Engineers Comments Regarding Surface Water Drainage

Application Reference:	AL/83/25/HH	Reviewer Reference:	ADC/KW/SB
Planning Officer:	Rhiannon Lloyd	Date of Review:	08/10/25
Site Name:	The Coach House, Norton Lane, PO20 3NH		
Application Description:	Erection of a garden room. (This application may affect the character and appearance of the Norton Lane, Norton Conservation Area).		
Assessment Number:	1 of 1

PROJECT:	The Coach House Norton Lane Chichester PO20 3NH
DRAWING:	02 - Existing and Proposed Site Plan
SCALE:	1:500
REV:	
DATE:	01/09/25

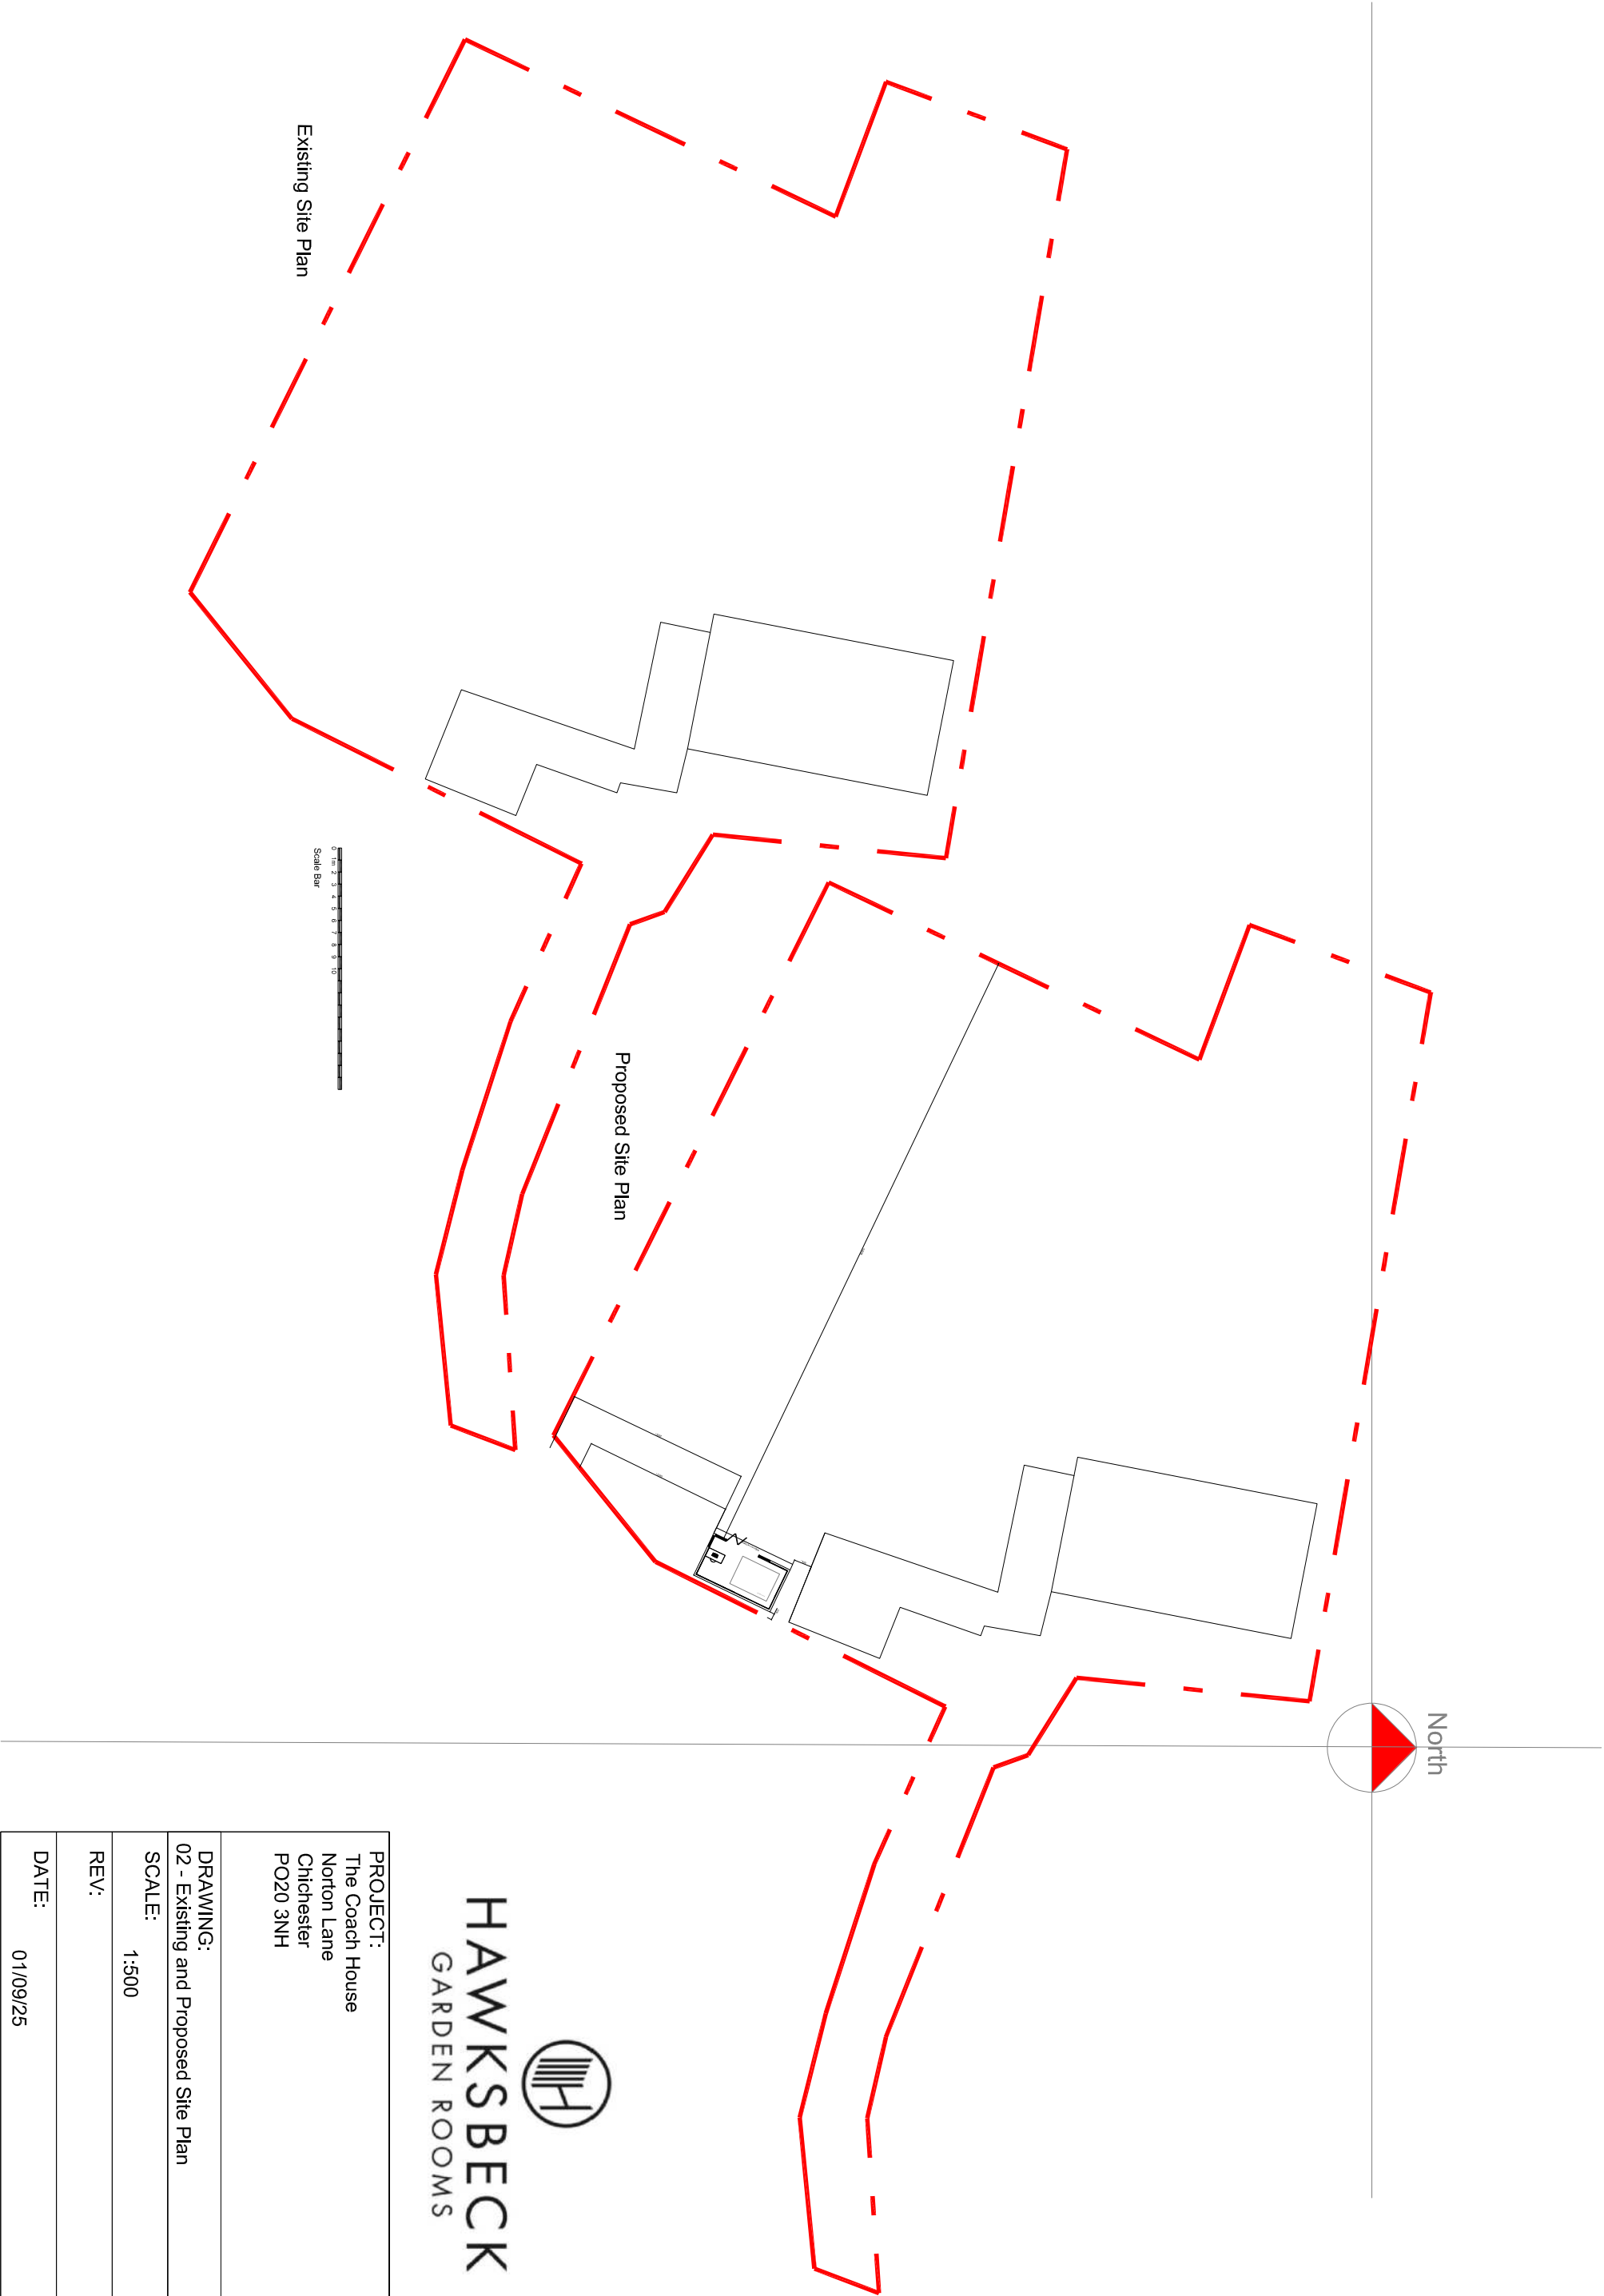
Insufficient information regarding surface water drainage has been submitted to evidence that flood risk will not be increased as due to the proposed development.

No surface water drainage runoff destination has been suggested. No evidence of any existing or proposed surface water drainage systems has been presented for review. It is the responsibility of the applicant or their drainage designer to provide this evidence. Without it, we are unable to assess whether the proposed development would increase flood risk. For this reason, we **object** to the proposal. The submission of such evidence may affect the scale and layout of the development.

The north western corner of the site is part of a Groundwater Source Protection Zone. It is acknowledged that the proposed structure will not be located in this area, however this should be considered by the surface water drainage design. If infiltrating features are located in this area, then the Environment Agency and Portsmouth Water should be consulted. It is expected that if infiltration is shallow then they are unlikely to object.

At present, no modelling or supporting evidence; such as ground investigations or drainage plans have been submitted for engineering assessment. In the absence this evidence, we cannot assess if flood risk will be increased by the surface water drainage of the proposed development. Therefore, this application does not accord with the NPPF as set out above.
